Subject: CU-14-00004 McIntosh Small Scale Event Facility
US 97 milepost 138.89 right

RE: CU-14-00004 McIntosh

RE: McIntosh CUP (CU-14-00004)

Re: McIntosh (CU-14-00004)

M MCINTOSH
7820 HWY 97
ELLENSBURG, WA 98926

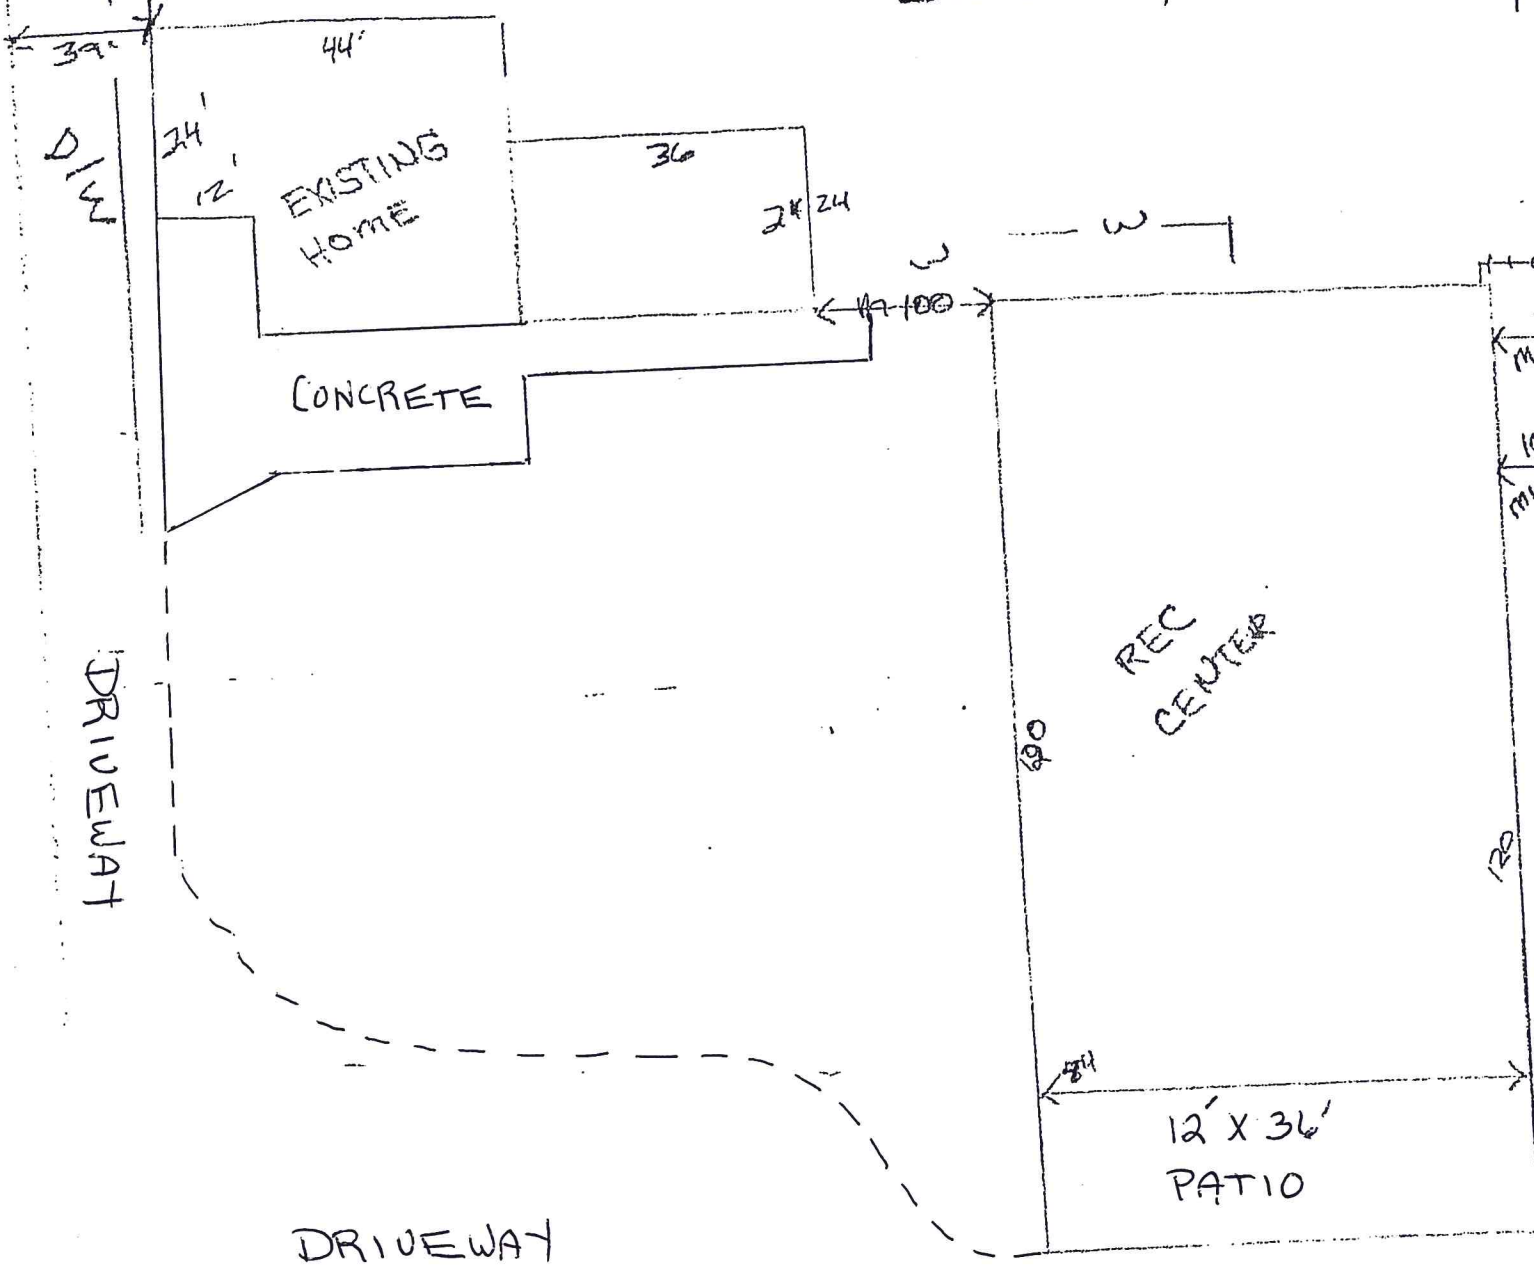
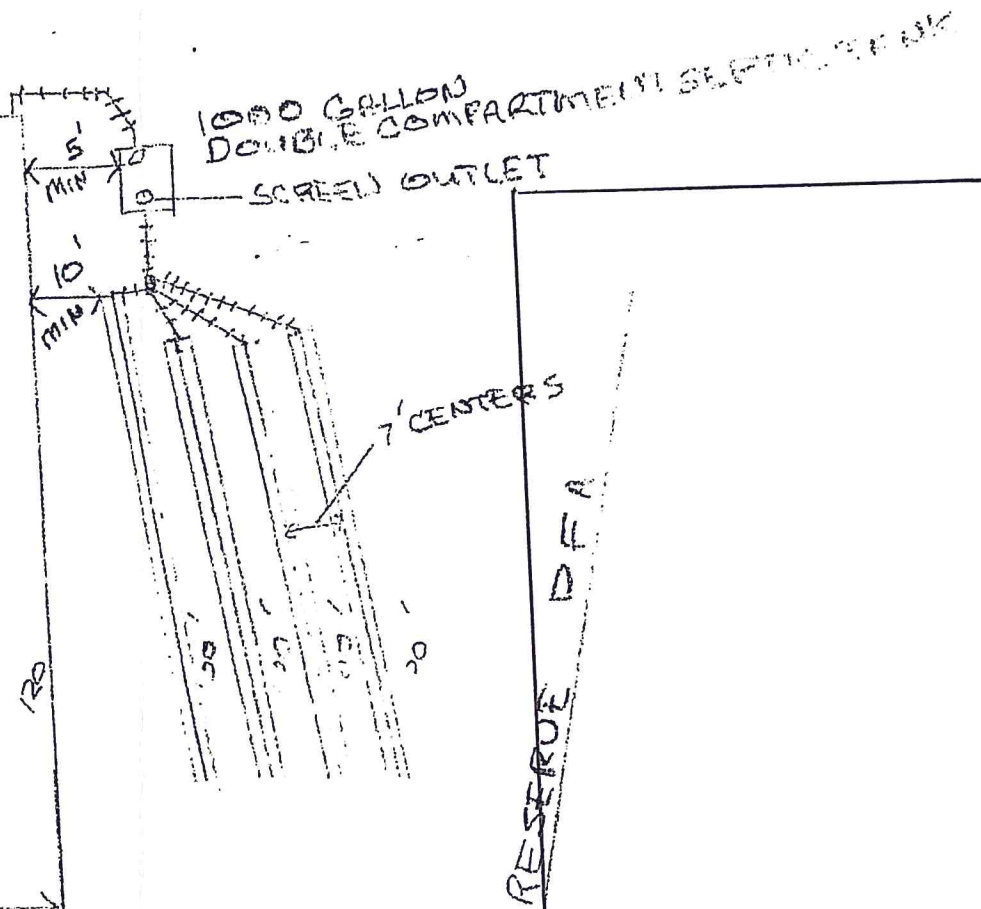
- The County should require the proponent to provide obstruction-free ingress/egress for two-way traffic beyond the approach to prevent vehicles from backing up onto US 97 while entering the facilities during events. WSDOT highly encourages the County to require the use of on-site signage and parking attendants to manage the entering vehicles. If events cause vehicles to back up onto US 97, WSDOT will require the proponent to construct a right turn lane at the proponent's expense.

- Parking will not be permitted within WSDOT right-of-way. Appropriate on-site parking provisions are required during events. The decommissioned roadbed lying parallel to US 97 on the east side of the highway is within WSDOT right-of-way.

- A turn-around shall be provided for fire department access.
- It would be best for any trailer traffic to park in the very back parking lot, with signage indicating parking for trucks/trailers.

- Passenger vehicle parking must be regulated so that emergency vehicles have full access throughout the facility. Signage and/or staffing for events should be provided so that people do not mistakenly park in a fire apparatus access lane.
